Client	Hallmark Care Homes		
Project	Proposed Care Home Pound Place Roundstone Road Angmering		
Drawing	Site Layout General Arrangement		
Date	Feb. 2018	Scale	1:250 @ A1
Drawn by	RAC	Drawing No	1388/001 W
Checked by	.	Status	Planning

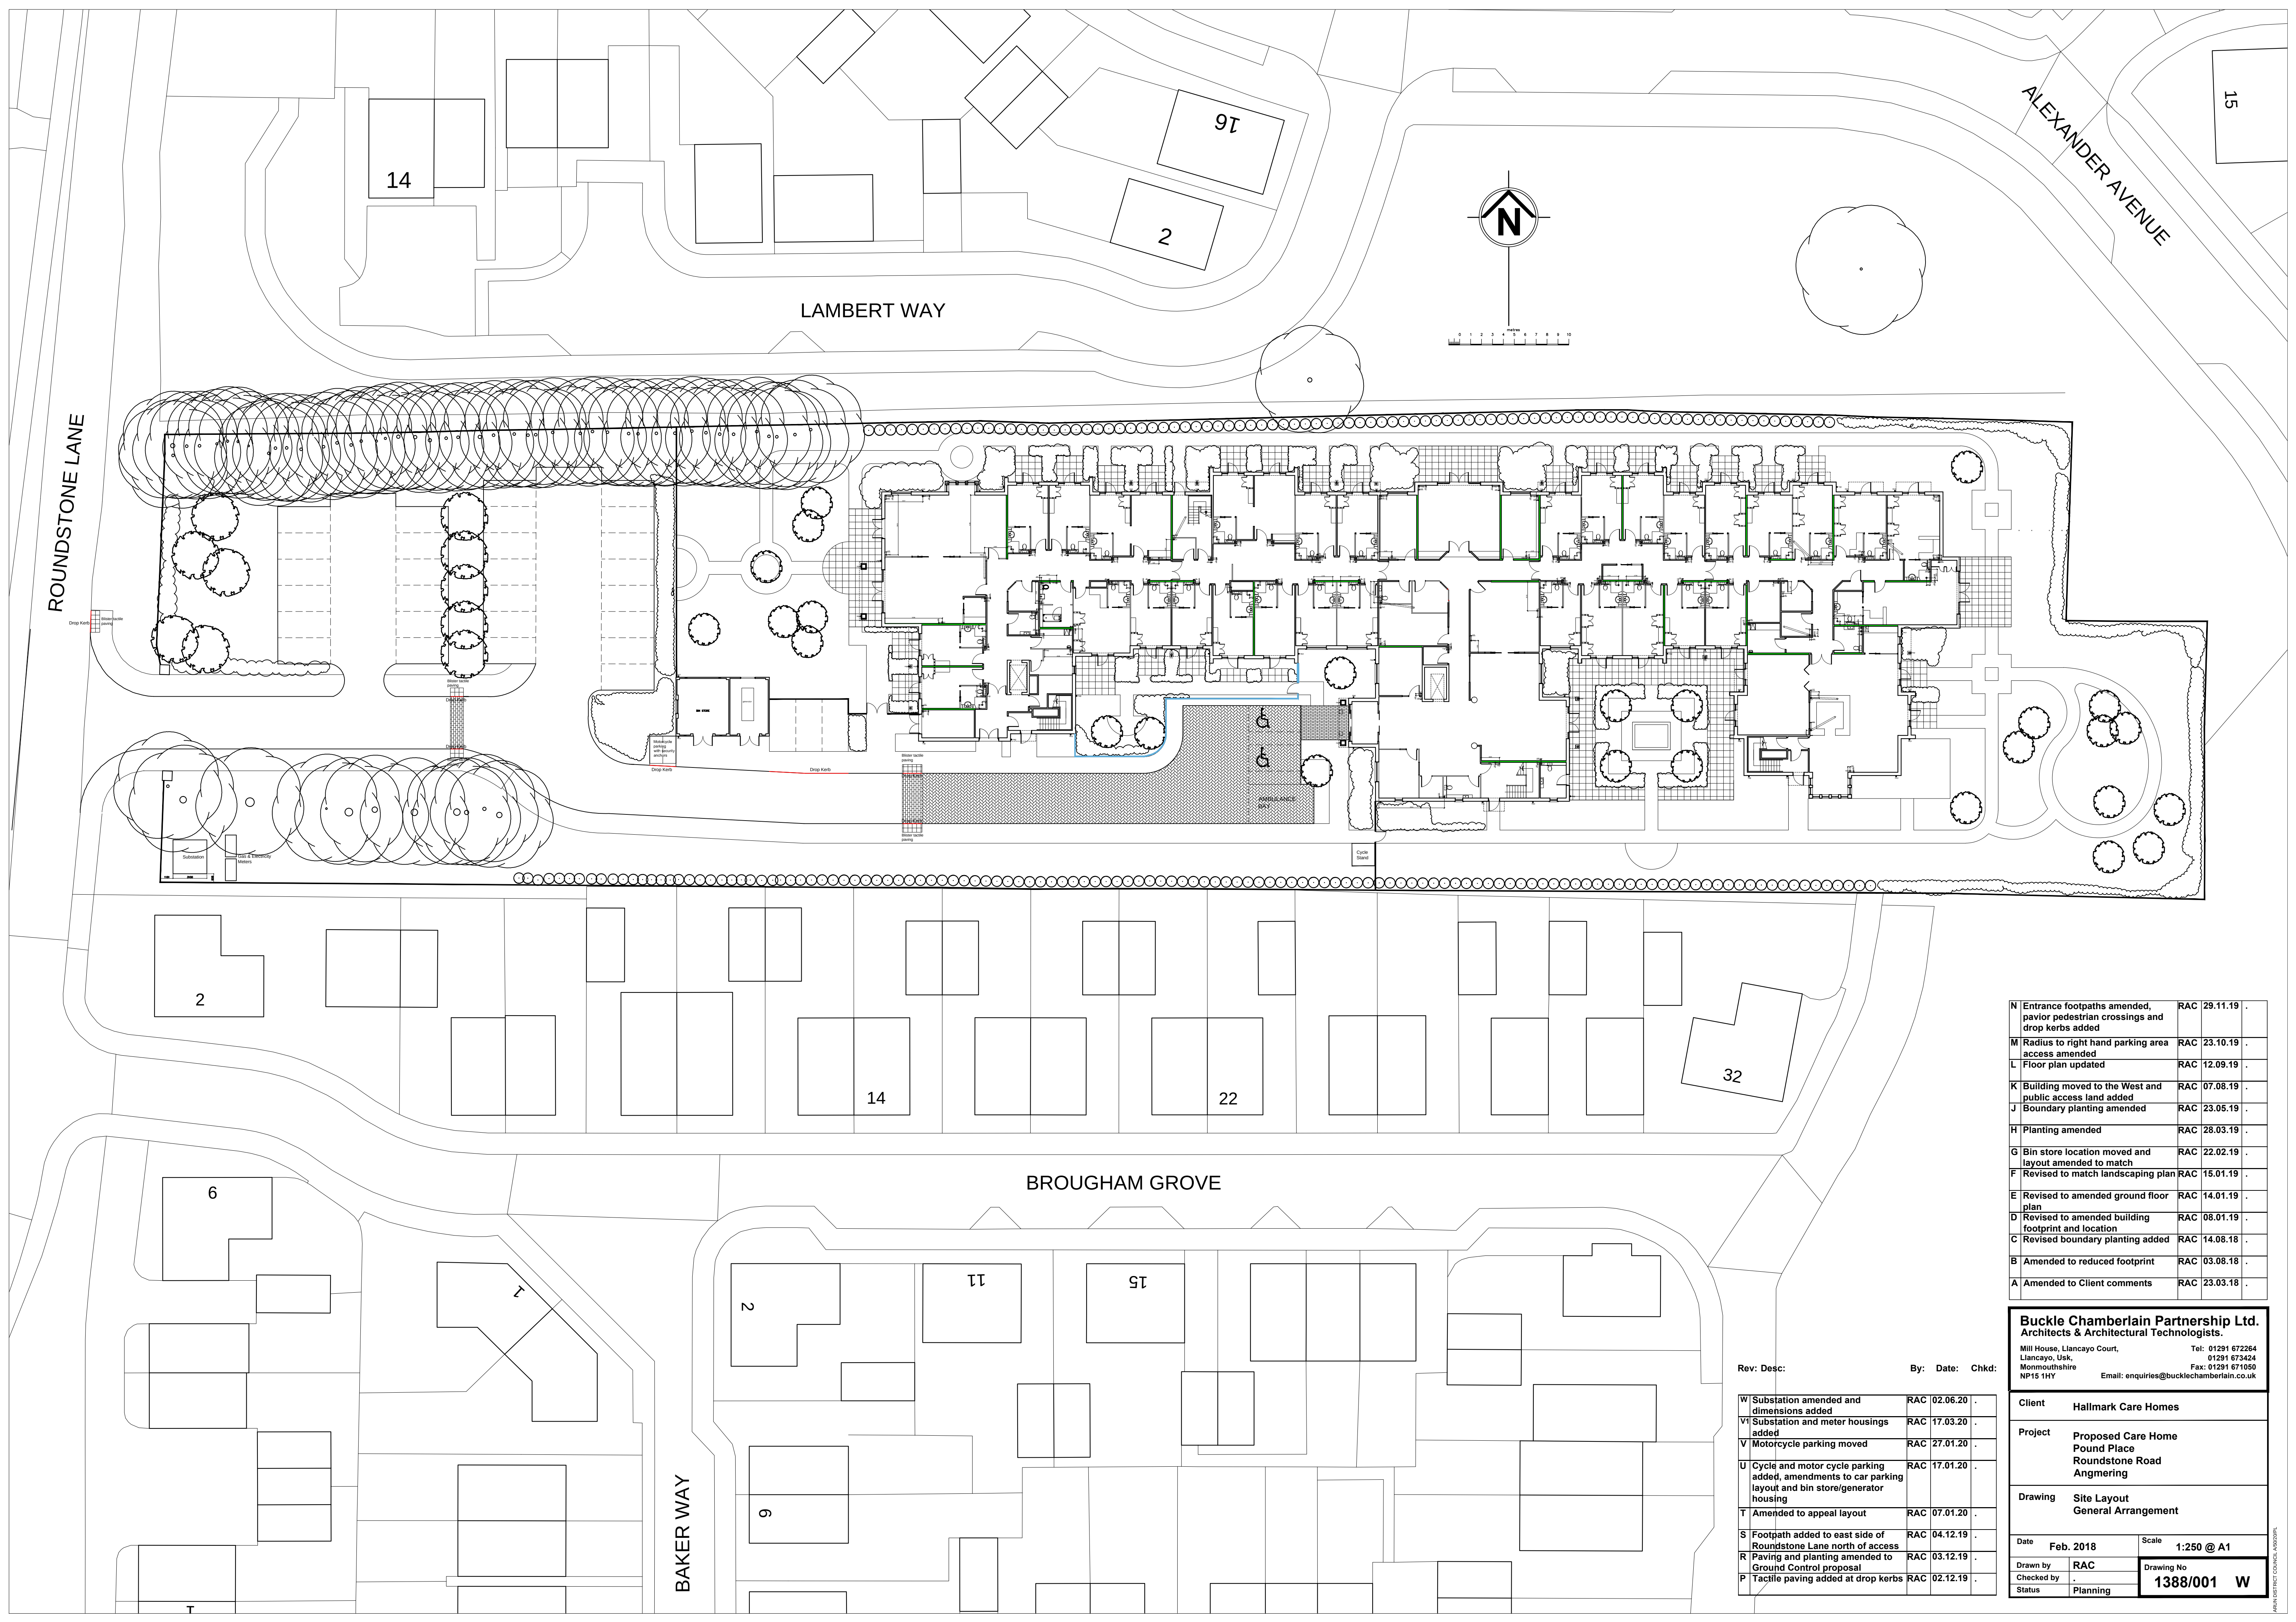
I have started to look at the above application in detail and notice that the drawing entitled Unit and Padmount Substation in a GRP Enclosure EDS-07-3102.01 rev C is incorrect. The Plan view of Site and Equipment refers to back edge of public footpath and the shape of the structure does not seem to accord with the block plan. Can you provide more precise layout details and clearly annotated elevations so that it is clear what elements of the structure are meter housing and generator and what will be visible from no2 adjoining the site and Roundstone Lane. I would also appreciate a street scene detailing the relationship and height of the structure in relation to the boundary with no 2 and proposed planting with a dimensioned distance from the boundary. Is there any opportunity to move the structure further from the site boundary to reduce the impact on the neighbouring property?

- Revised site plan with the correct size and location of the substation including dimensions.
- Correct drawing for the substation.
- Part elevation of the southern boundary showing the substation.
- Revised proposed site boundary drawing.
- Revised general arrangement landscaping plan.

I have discussed the matter of moving the substation with both the M&E Engineer and the Landscape Consultant and there is no scope for this due to the proximity of the existing, retained trees between the substation and the access road.
